**Design Summary Document Appendix E WSCC Questions dated 090321 PF Responses
Document 040521**

Comment provided by WSCC 09.03.21

Structures Contains ‘Front-End’ pack for railway overbridge – so scope, annotated drawing and impacts summary. This has been referred to Andrew Cook in WSCC Structures Team and as-of 11/02/2021 comments from him are found below: Based on the info provided the following structures are to be provided; i. A single span structure over the railway, allocated structure ref: 1779	Responses as per below

A13394-PF-ZZ-XX-DR-CD-00106 P06

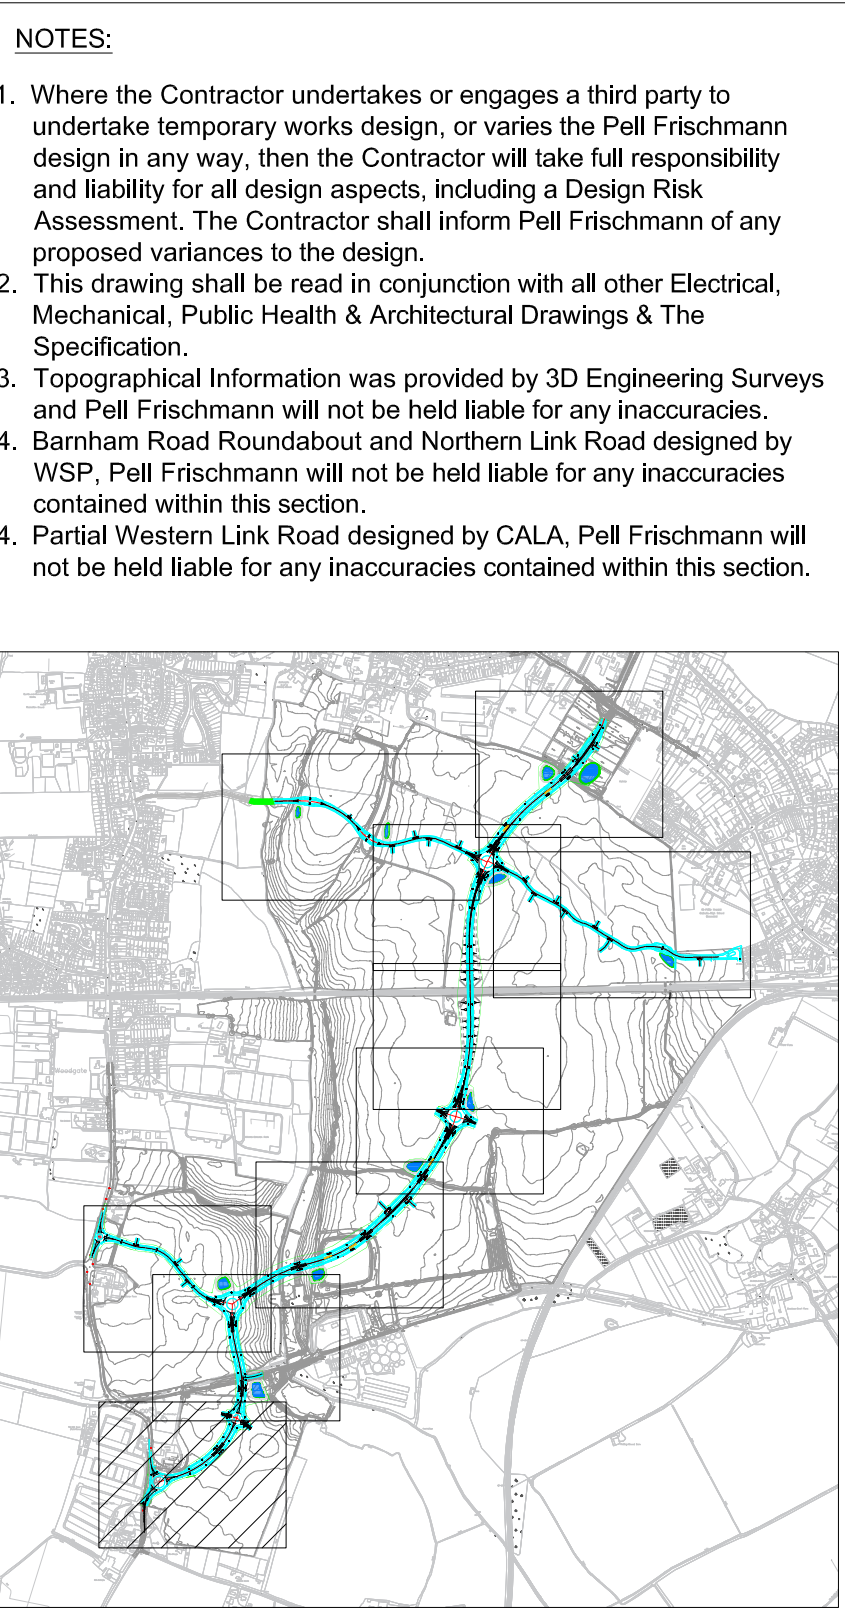
Q33	Junction visibility splays These are not currently shown along the new A29 alignment.	These are now shown on the drawings
Q34	Shared cycle and foot infrastructure. Shared cycle and walking infrastructure either-side of the new A29 alignment. No design documentation in support of these has been provided. Therefore, it will need to be demonstrated how ALL routes comply with LTN 1/20.	A 4m wide segregated route has now been proposed in line with the minimum requirements of LTN 1/20
Q35	Side road widths. Some of the side roads appear somewhat wide at 7.3m. Clearly at this stage the full details of what each is intended to serve is not available. However, the applicant should ensure that all are suitable for their intended purpose – moreso when bus and coach facilities might be proposed (e.g. new waiting facility for Barnham Railway Station). Localised widening on bends etc. would be required if such vehicles were to use these routes on a regular basis. Very little detail shown here to enable an informed response. A road width of 5.5m is shown close to the new railway station car park whereas the rest of the access road is wider. With buses etc. using this link, 5.5m might not be suitable.	In line with MfS 6.5.7 the road has been revised to be a minimum of 6.0m or more.

Highway Drainage
Layout
(Sheet 9 of 10)

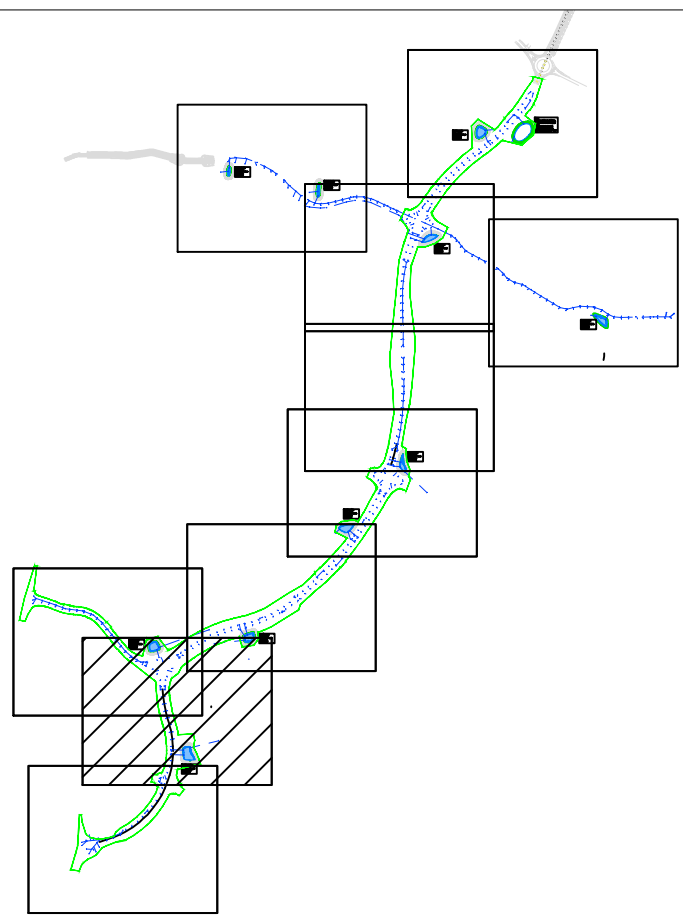
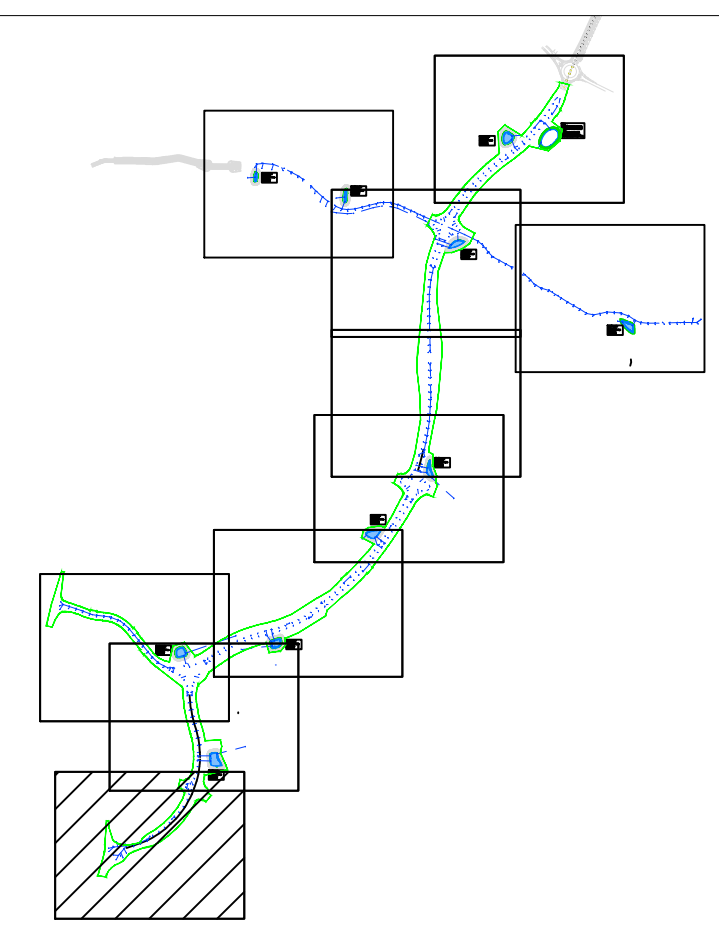
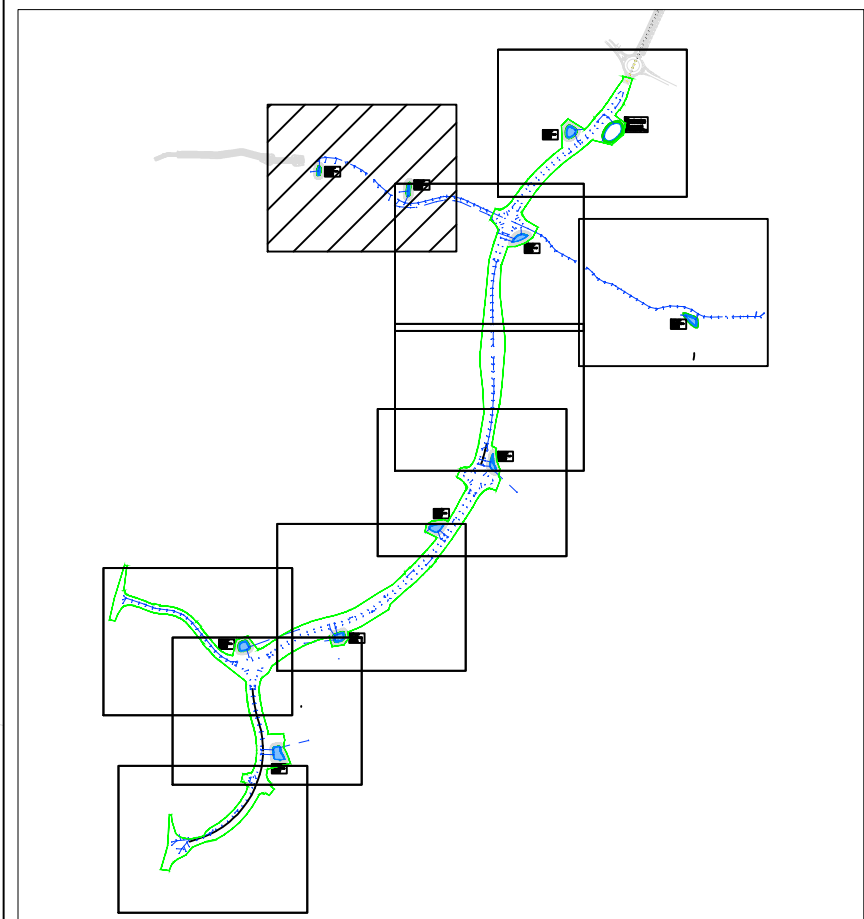
BEW-PF-GEN-XX-DR-C-0530 P4 (Highway Drainage Strategy).	
Q66	The key doesn’t provide enough detail. Why are certain parts of the road shown in a ‘buff’ colour and others in red?	The difference in colour is to show the provisional catchment areas split for highway runoff. This will be added to the key on the next revision for clarity. See above response
	BEW-PF-GEN-XX-DR-C-0531 P4 (Lidsey Rife Crossing (North))	
Q67	Q. Lack of detail of Rife crossing points (other than reference to culverts). Would culverts be acceptable or are more substantial measures required?	The indicative culverts are shown on dwg 533 which the note on dwg 531 refers to.
Q68	Q. Are ‘split’ carriageway arrangements acceptable on side road links (and on main A29 if shown)?	Not sure of the question being raised here?
Q69	Details of bridge adjacent to Cala Homes land required.	The proposed bridge structure does not form part of this Planning Application. The bridge structure will be submitted by Cala Homes when it comes forward.

Design Summary Document Appendix A dwg -00106 Po6

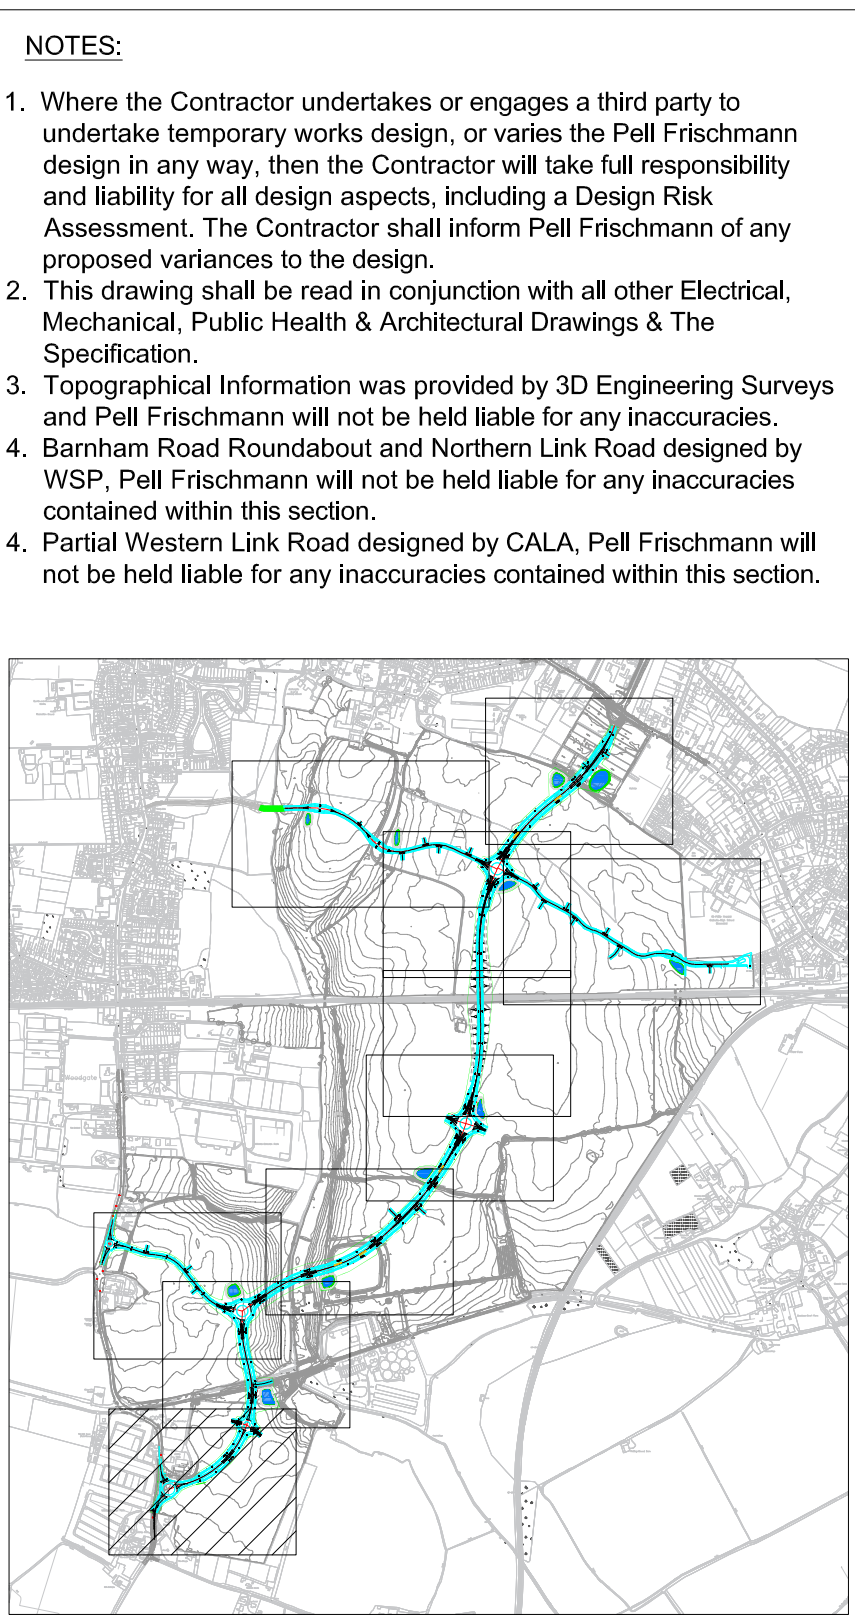
Junction separation and junction treatment/design.	
Q63	On A13394-PF-ZZ-XX-DR-CD-006 junction separation and junction treatment/design is shown for what appear to be uncontrolled road junctions.	As per drawing A13394-PF-ZZ-XX-DR-CD-0001 issued previously these junctions are left in and left out with a central island on the A29. Therefore movement and interaction between these junctions is not possible.
	Will these junctions be provided with RHT lanes? And if so, does the separation meet DMRB requirements? If not a DfS would need to be considered although it is preferred to design-out the need for DfS’s. (This point is also referred to elsewhere in this document).	As per the above response not RHT is proposed.
	Land boundaries and impacts on existing local accesses and junctions (A13394-SK024 Rev ‘C’).	
Q65	From the scale and level of detail shown on the drawing, it is not possible to establish impacts on existing junctions and accesses found adjacent to the southern tie-in. This needs to be shown far more clearly on any future drawings.	We have provided a larger scale drawing showing more detail
